From: Matthew Kettleborough
Sent: 26 November 2024 09:50
To: Victor Grayson
Subject: RE: app no 2024/92395 - former Kirklees College, New North Road, Huddersfield

We can confirm that the car parking area has been amended in order to address the amendments to the Lidl Store Footprint. I am currently obtaining a Swept Path analysis.

PROPOSED SITE PLAN.

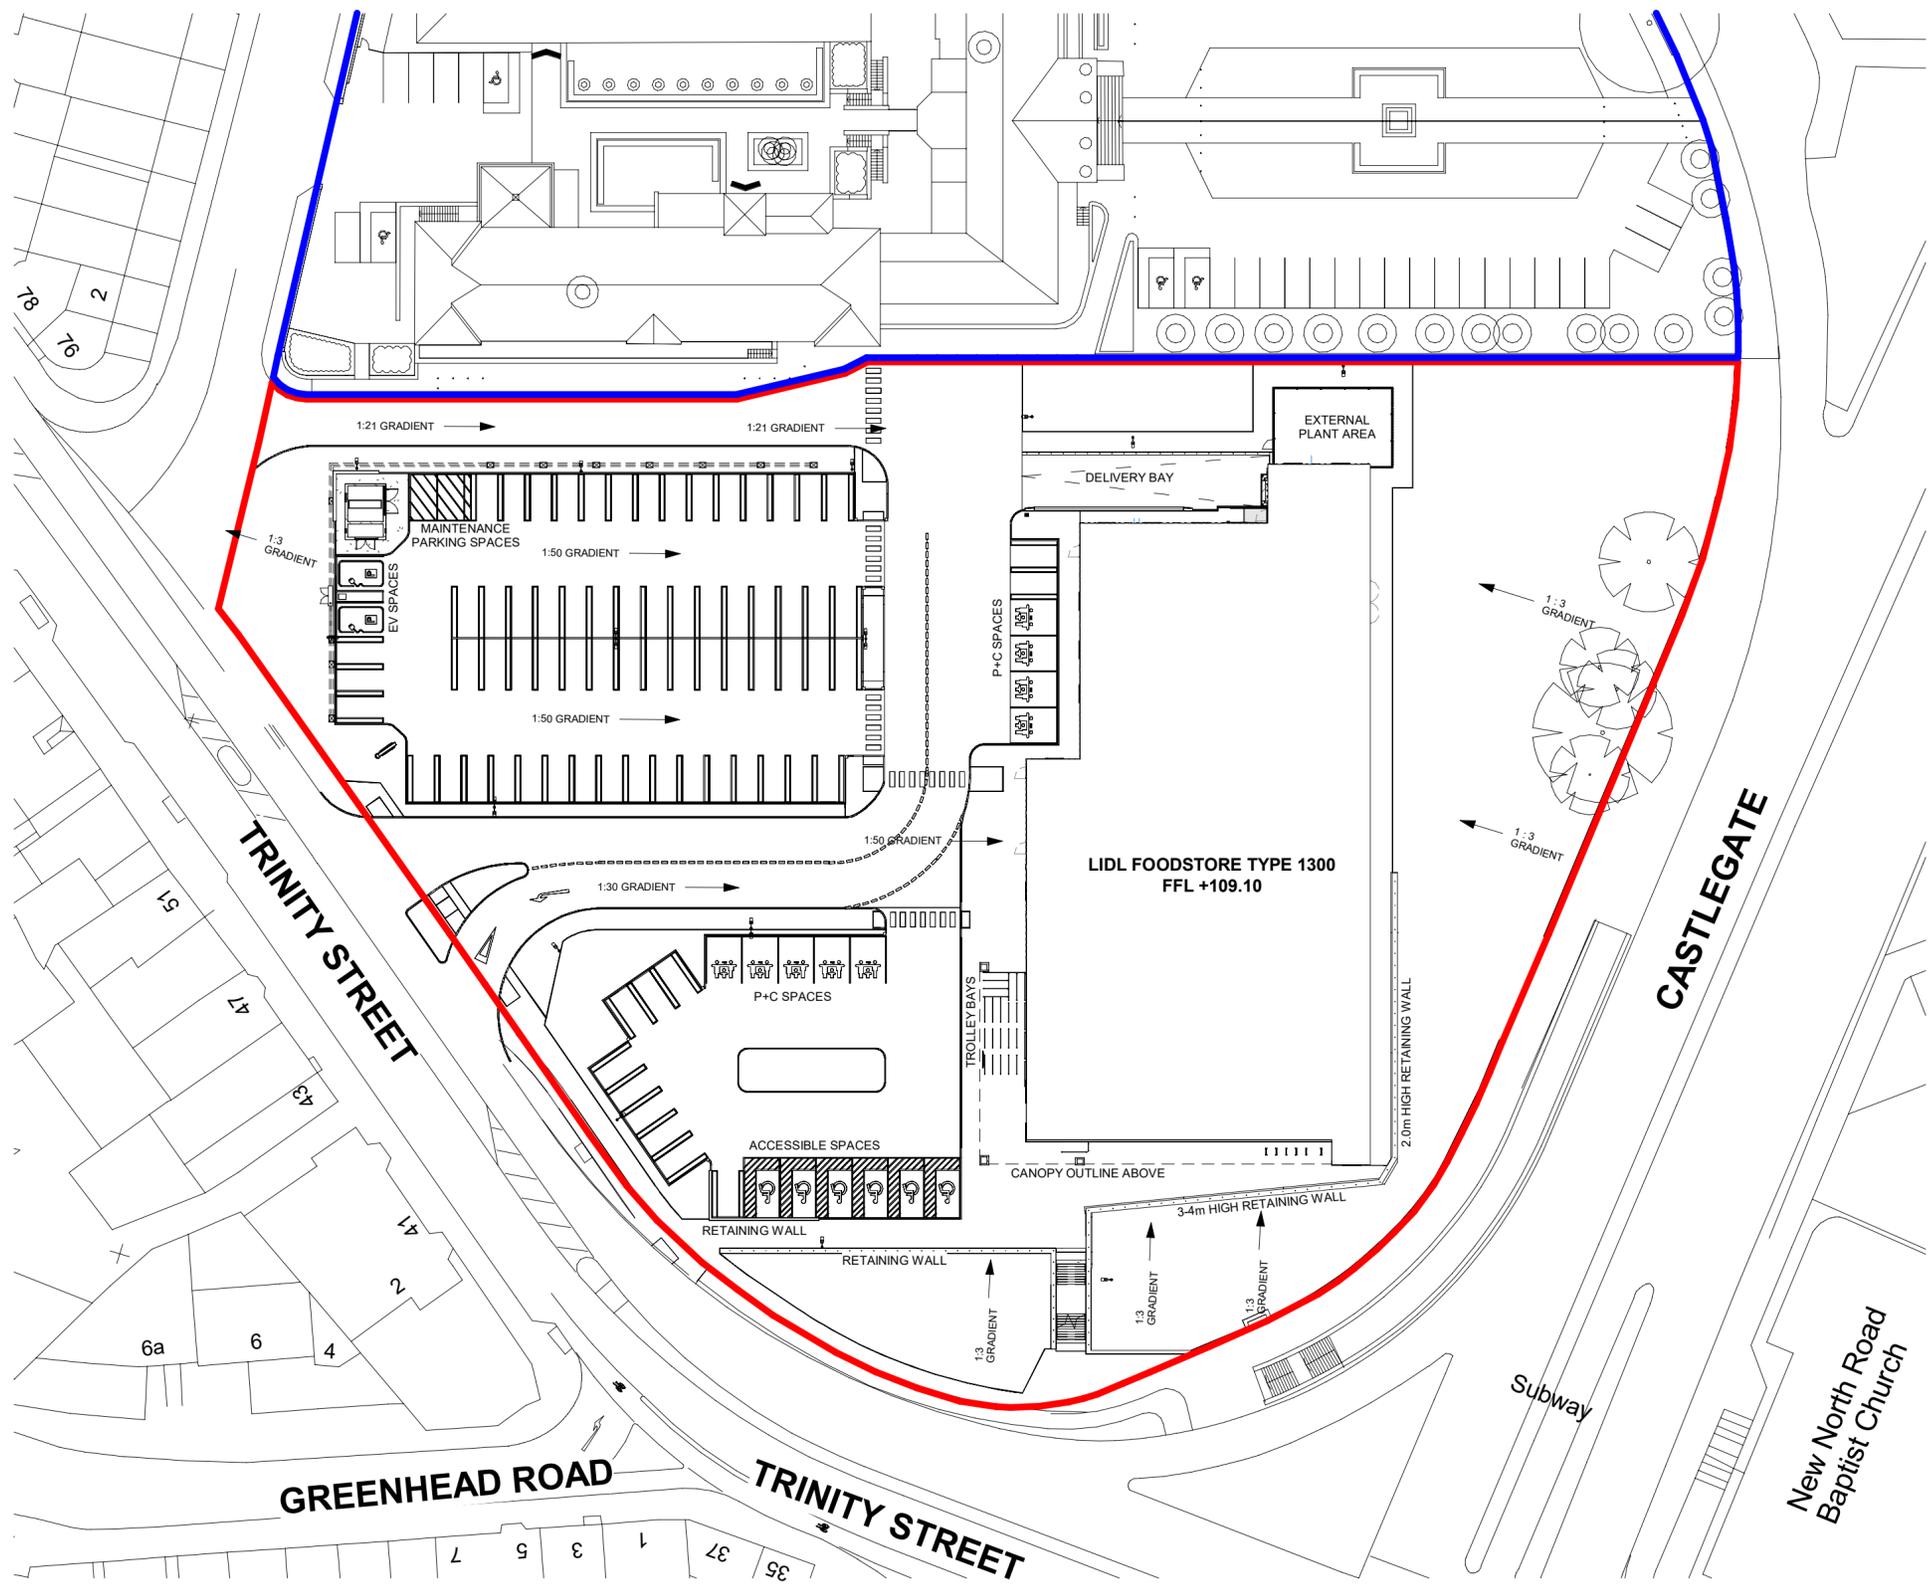
In regards to numbers they have changed from the following:

Existing

STANDARD SPACES 113
PARENT CHILD SPACES 8
DISABLED SPACES 6
GRAND TOTAL 127

Proposed

EVC SPACES 2
LIDL ACCESSIBLE SPACES 6
LIDL MAINTENANCE BAY 2
LIDL STANDARD SPACES 74
PARENT&TODDLER SPACES 9
GRAND TOTAL 93

The southern part of the parking layout has been amended to incorporate more parent-child and in order to move the accessible spaces in line with the new store footprint.

Two EVC spaces have also been introduced in the northern part of the car park, and the substation area has also been slightly enlarged.

The pedestrian crossings have also been amended to suit the amended layout operations.
